**Subject:** Y/88/21/DOC

Please see below the comments of our Drainage Officer.

Condition 5

Appendix I – Proposed Drawings

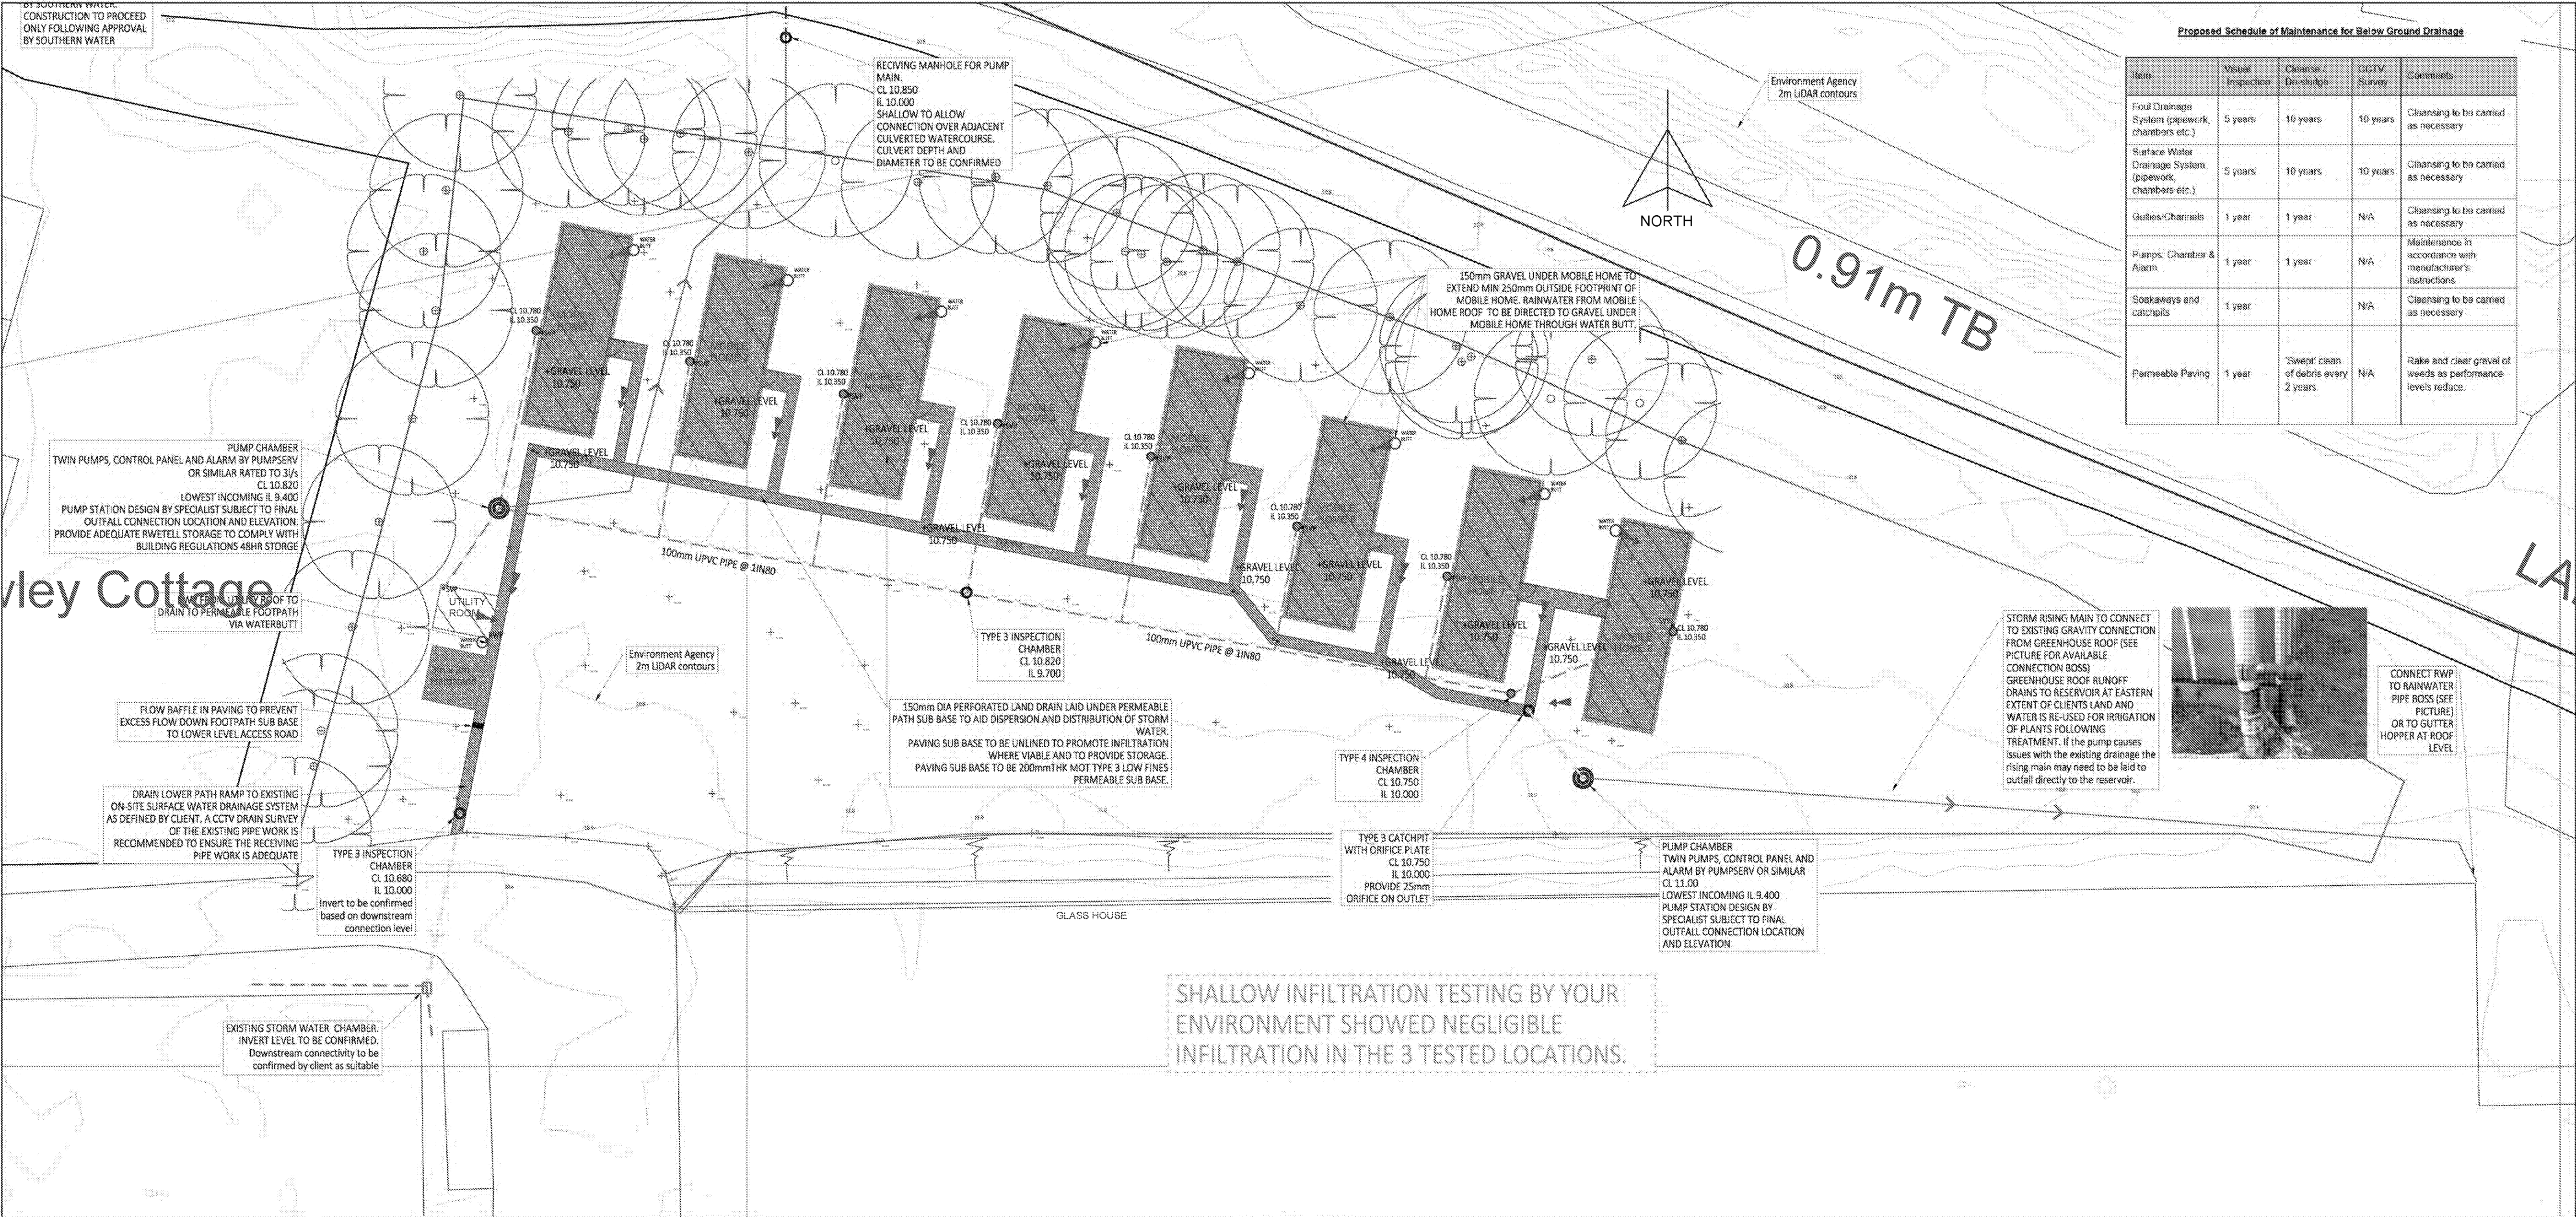
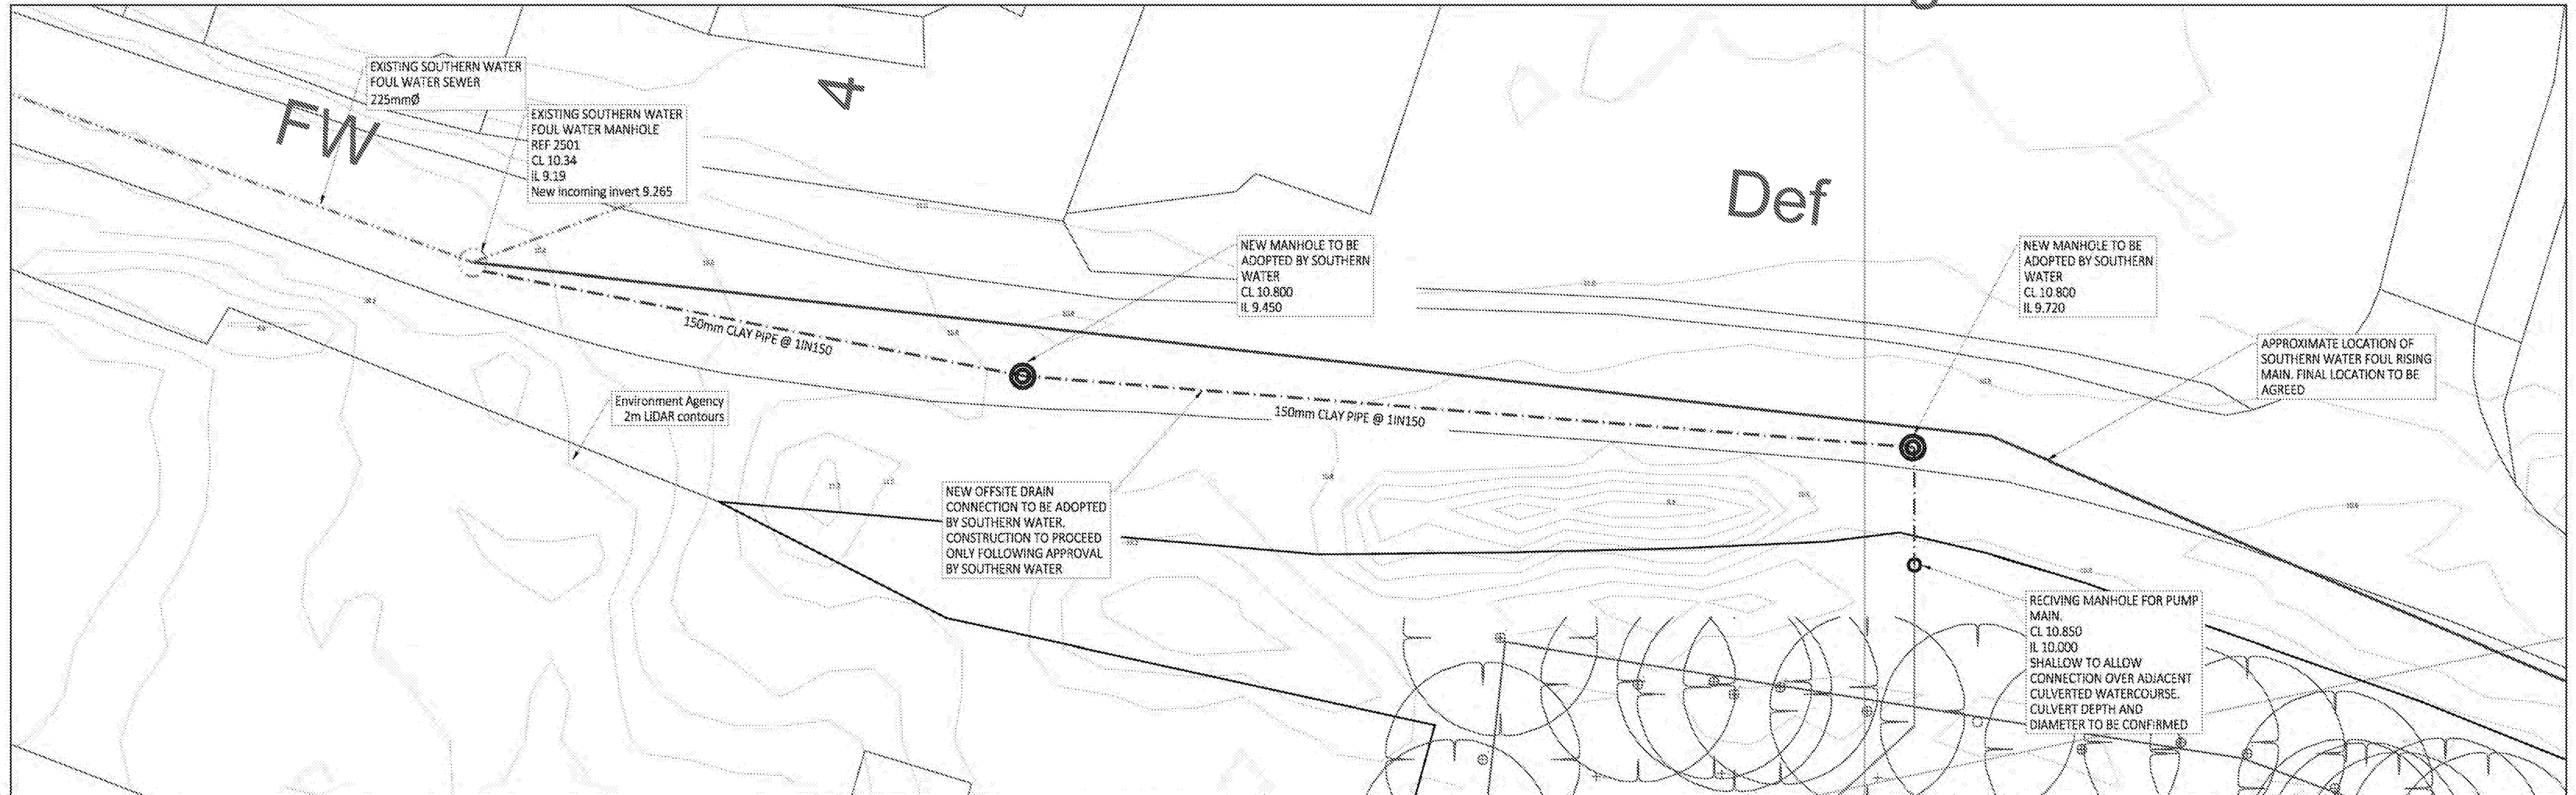
1. The applicant has completed summer infiltration testing which indicate infiltration is not viable.
2. No winter groundwater monitoring results have been provided, this information must be supplied to evidence that groundwater will not get into the surface water drainage system.

3. The proposal is for an unlined system to be pumped. This could in winter result in groundwater being pumped.
4. Pumping is not supported, it is not a sustainable solution. Pumps also fail and can result in increased flood risk both on and off site. The applicant must submit a revised gravity scheme.

5. The proposals are to pump surface water to the on site reservoir. The statement claims that no surface water will be discharged off site. No evidence has been submitted to evidence that either the existing surface water drainage network or reservoir have the capacity to accept these additional flows. The reservoir must also have an overflow to somewhere for water to be discharged in times of exceptional rainfall when irrigation demands are less, i.e. the winter. Therefore the statements provided are not supported by ourselves.

It is not possible for us to recommend discharge of this condition at this time with the strategy presented. A fully revised surface water drainage design is required, which may involve a gravity outfall to watercourse.
